**WELWYN HATFIELD COUNCIL – DEVELOPMENT CONTROL**  
**DELEGATED REPORT**

<b>APPLICATION No:</b>	<b>S6/2009/2307/FP</b>
------------------------	------------------------

This application seeks full planning permission for erection of a front extension to the garage granted under planning application S6/2008/2412/FP. The proposed extension would measure approximately 3.2m in width x 3m in depth with a pitched roof and approximately 3.7m in height. The garage extension would be finished in white render and tile to match existing.

Elevations:
1:100 Front (NE facing)

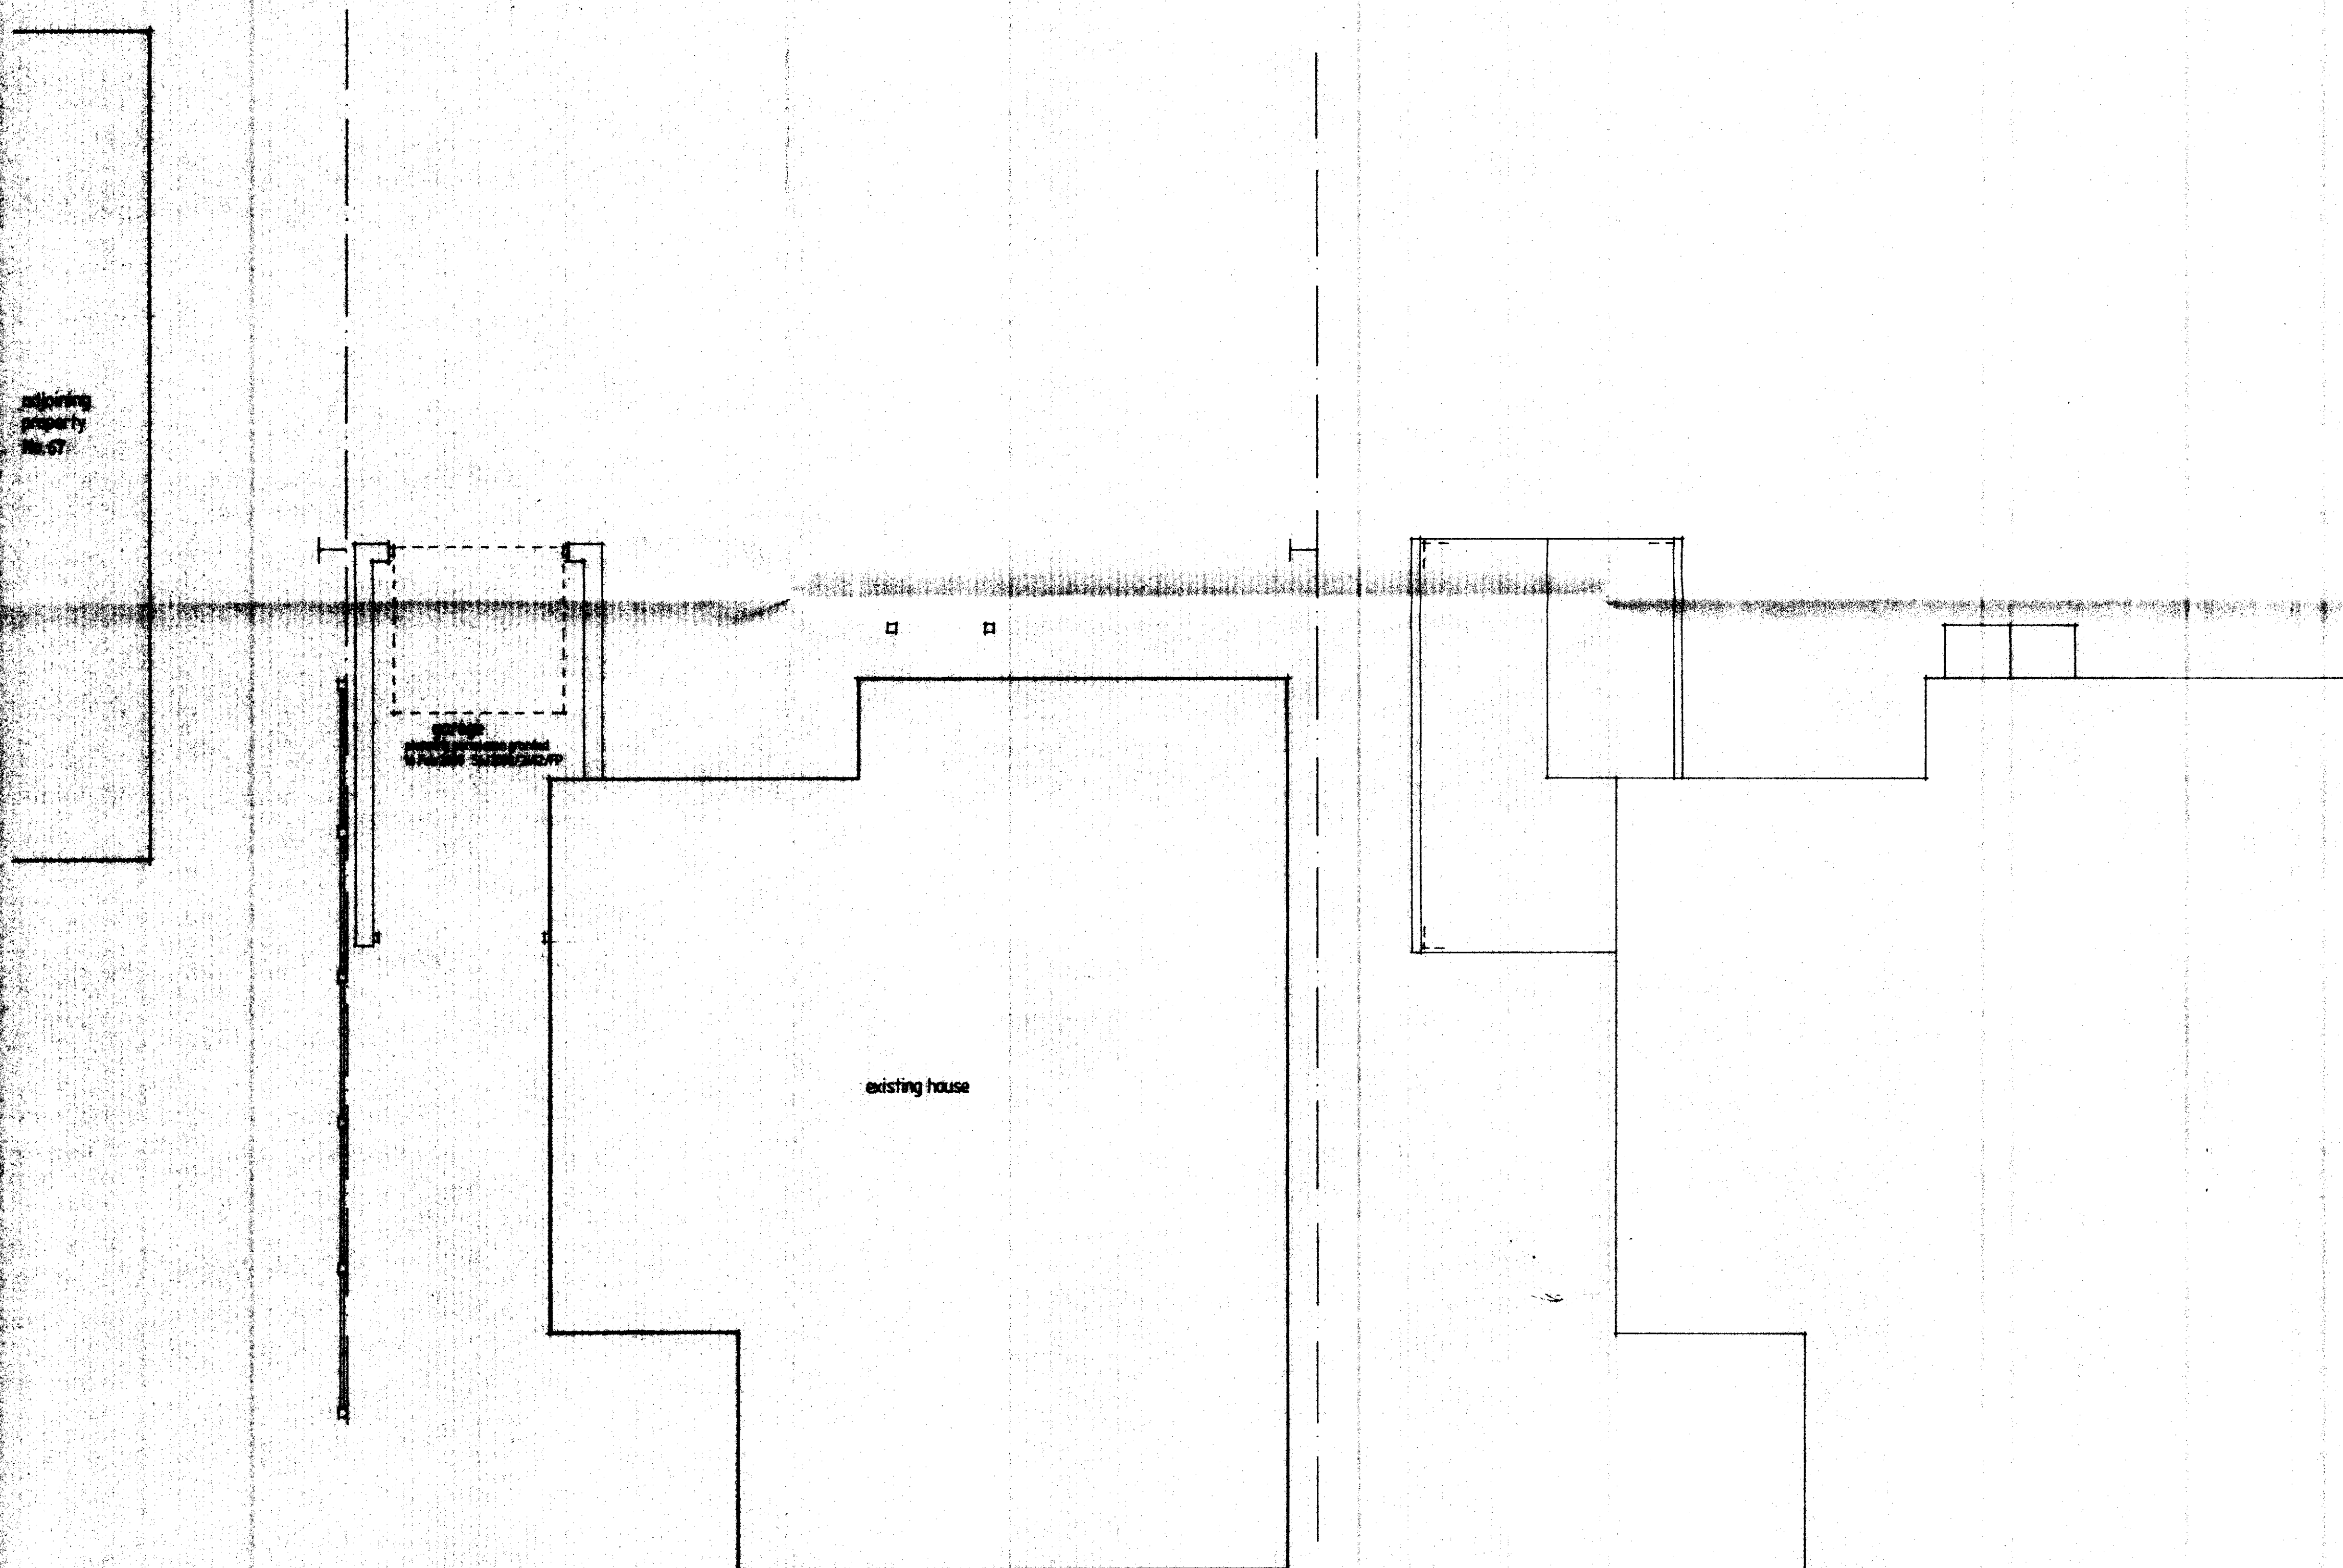
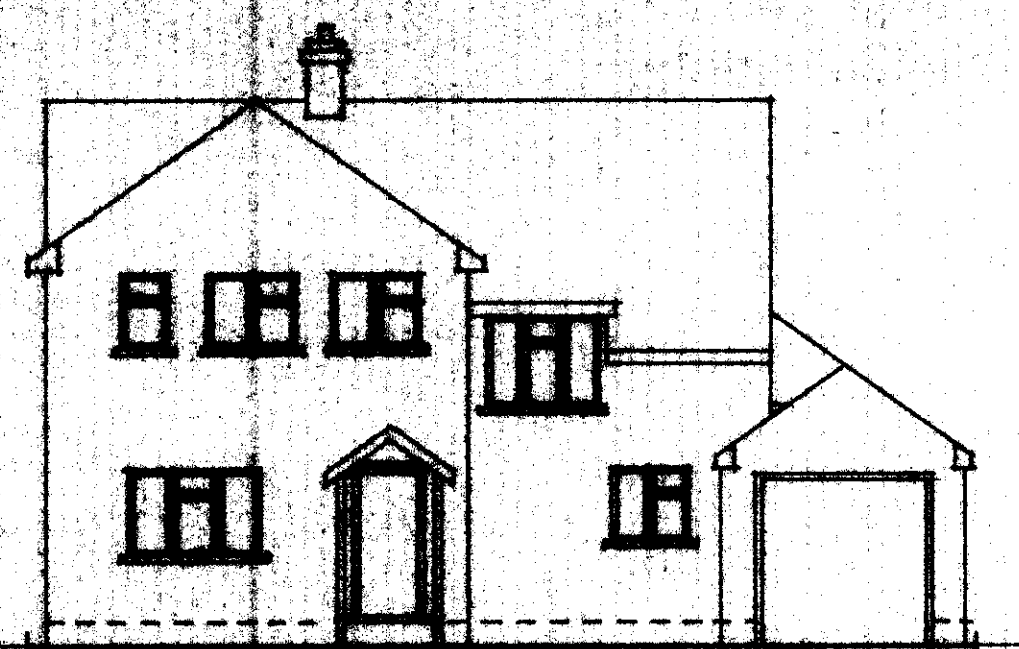
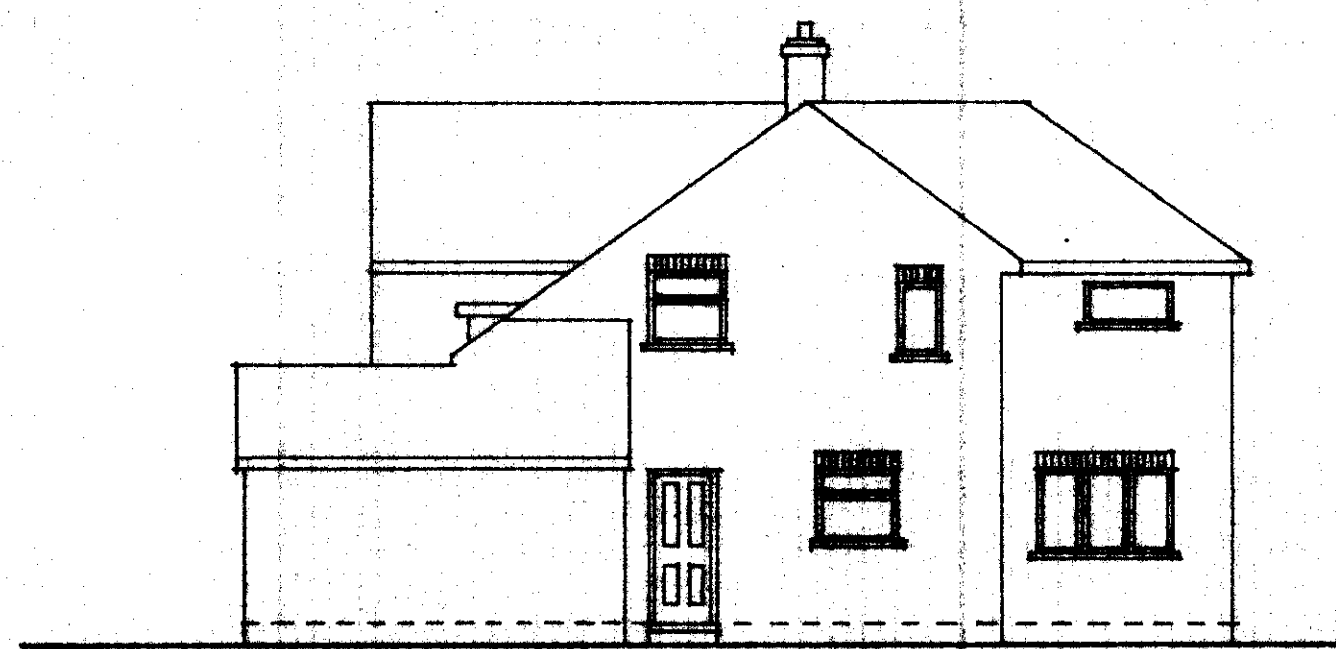
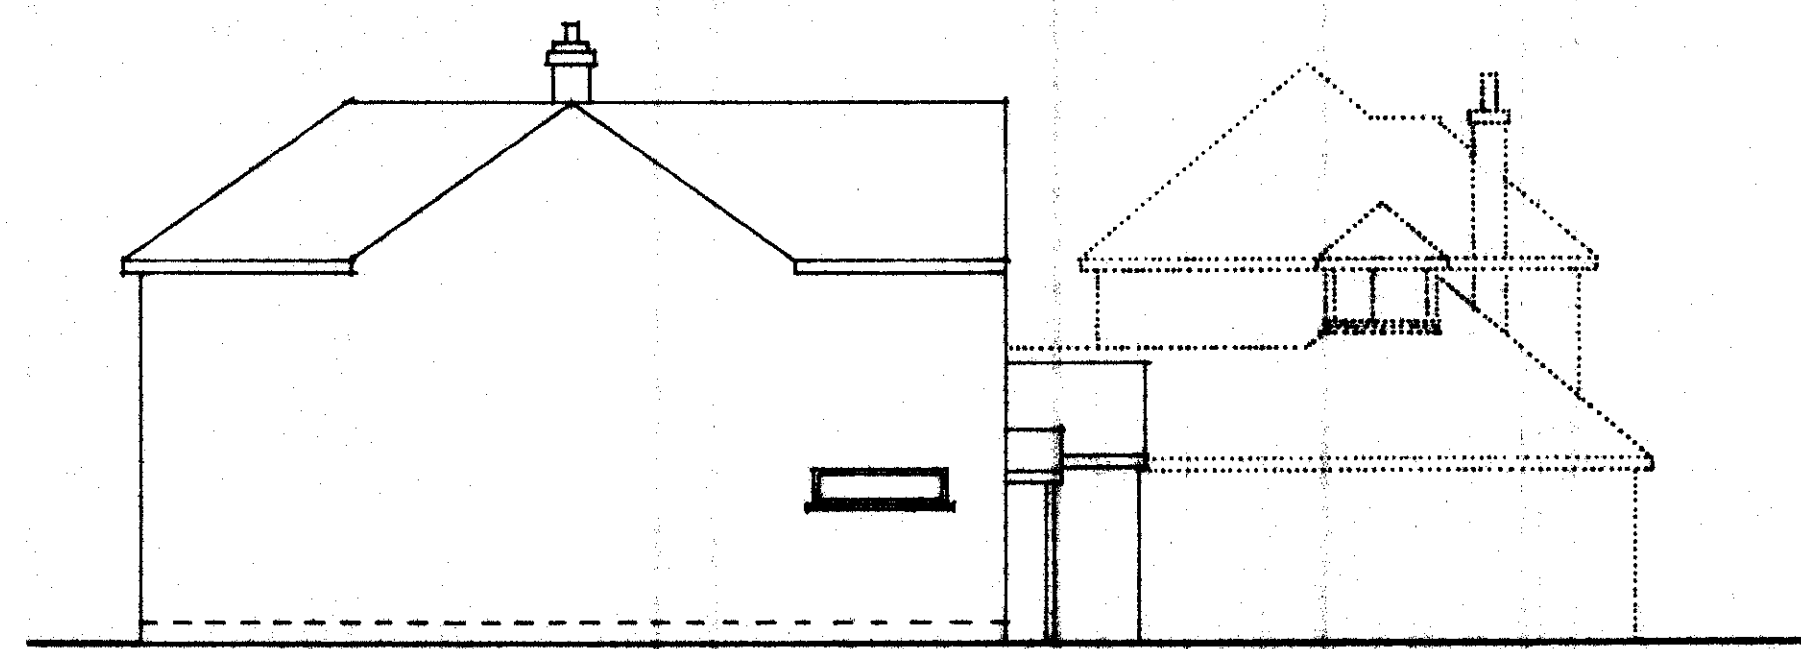
The extant consent which has been implemented includes a replacement garage located to the side and projecting forward of the application dwelling. The garage, which has not yet been completed, would measure 3.2m in width and would extend 3m forward of the adjoining front wall and 1.7m forward of the existing gable projection to the front of the dwelling. The current

application proposes a further 3m projection to the front of the garage which would result in a total projection of 6m.

The proposed front extension fails to complement the design and character of the application dwelling and other dwellings within the immediate streetscene. The proposed extension, by virtue of its depth, would result in a projection that is out of scale with the existing dwelling. The proposed extension would represent an incongruous addition and dominant feature that would cause harm to the established character and appearance of the application dwelling and to the visual amenity of the street scene.
